From: Contact Centre (CRM) <contact@ribblevalley.gov.uk>
Sent: 17 June 2025 11:42
To: Planning
Subject: Planning Application Comments - 3/2025/0357 FS-Case-723698741

Planning Application Reference No.: 3/2025/0357

Address of Development: Horrocksford Hall Farm, West Bradford Road, Clitheroe

Comments: These comments on application 3/2025/0357 are provided on behalf of [REDACTED]

Proposed West (Front) Elevation

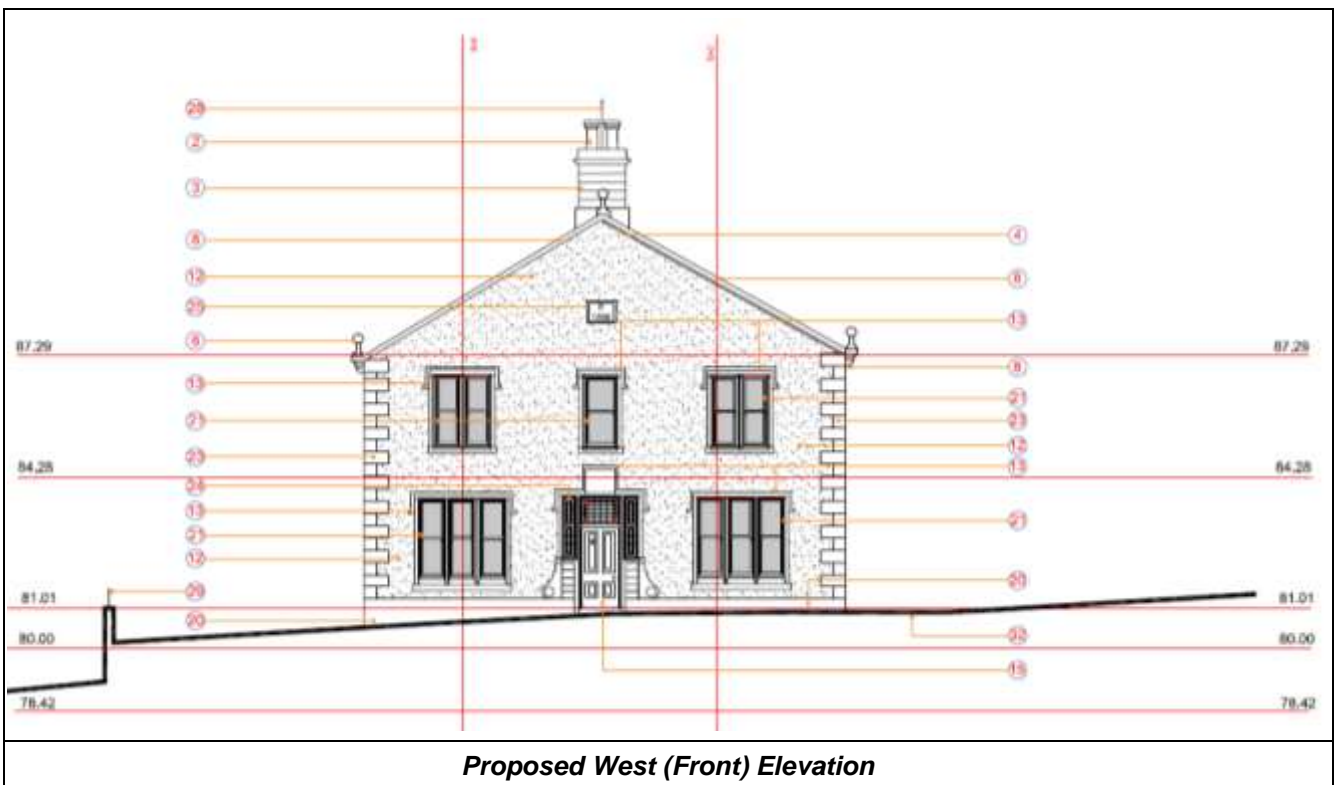
PVC-u windows are not appropriate for use on historic buildings and would be harmful to the character of Horrocksford Hall Farmhouse and to the setting of the listed Horrocksford Barn, and we recommend these are replaced with suitable timber-framed windows. Any remaining timber windows should be assessed for suitability for repair and retention. Guidance on suitable windows for historic properties is available in the Historic England Advice Note on Traditional Windows: their care, repair and upgrading, here: <https://historicengland.org.uk/images-books/publications/traditional-windows-care-repair-upgrading/heag039-traditional-windows-revfeb17/>

Ground Floor Plan

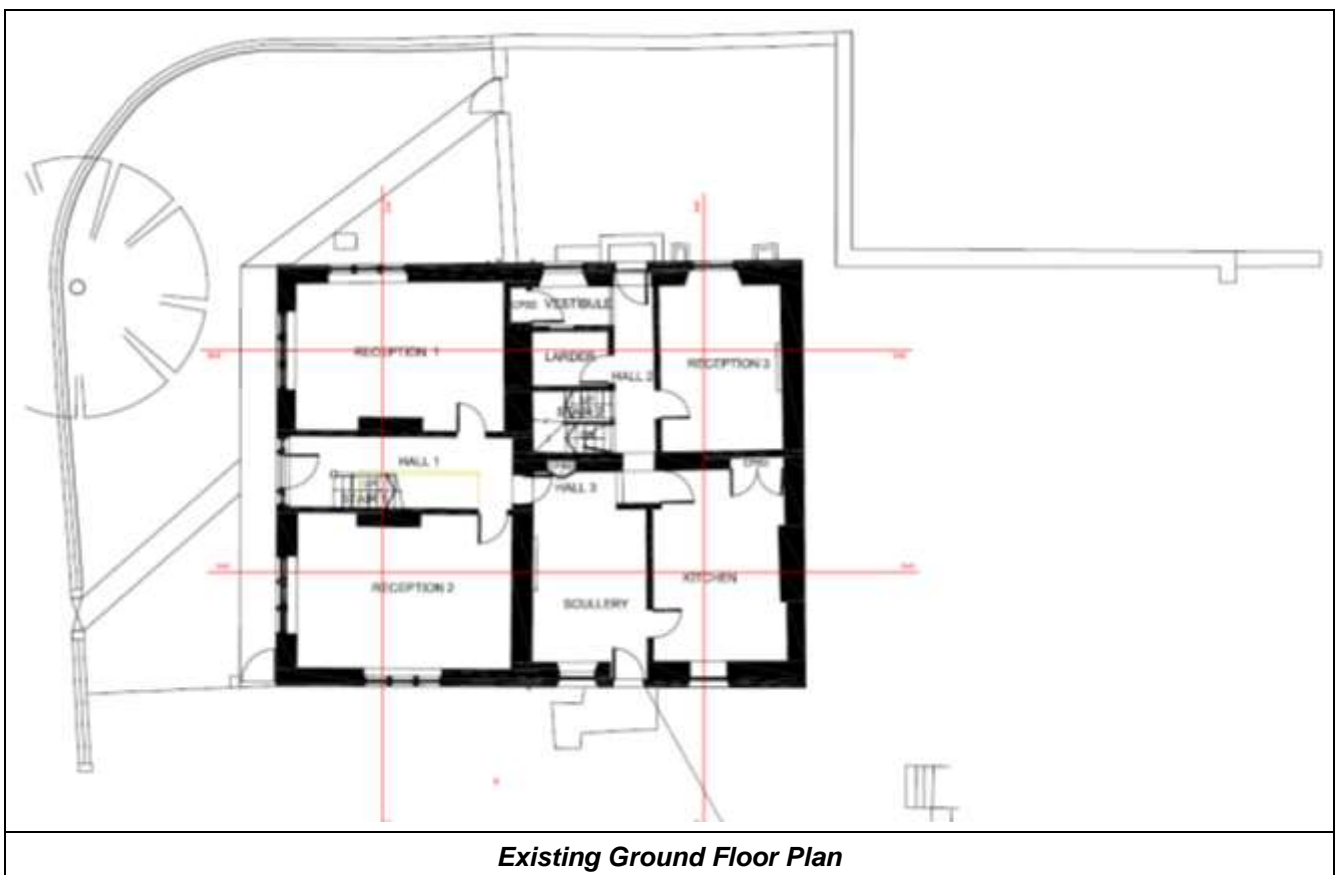
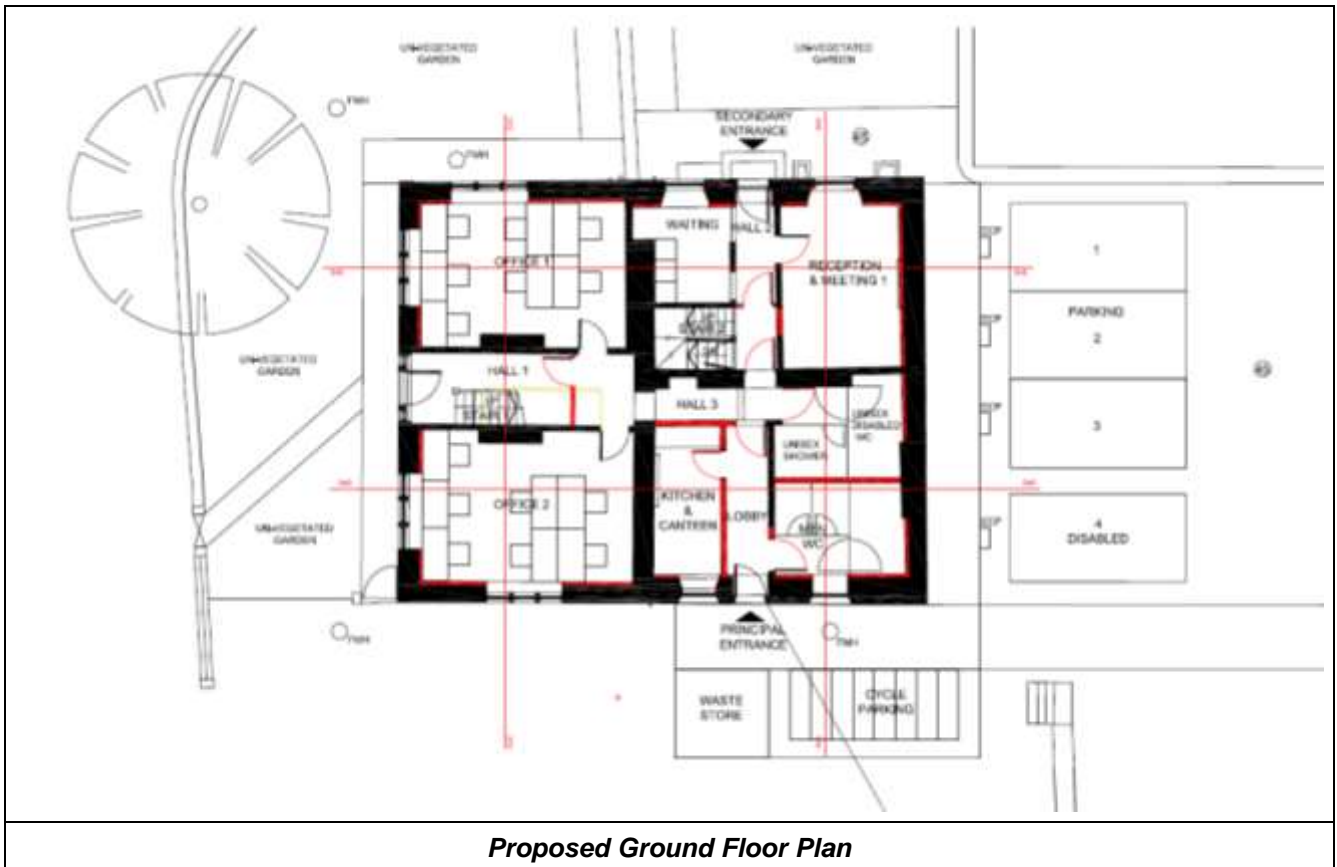
We also consider that it is inappropriate to divide the kitchen by putting a wall in the middle of the historic range to create toilets and a shower. This is a fundamental change to the plan form and will alter the character and understanding of the space by obscuring the main surviving historic feature. There is no clear justification in the application for why the room needs to be divided in this way. Likewise, the removal of features such as stone shelves in the larder and the opening up of this space will impact the significance and understanding of the building.
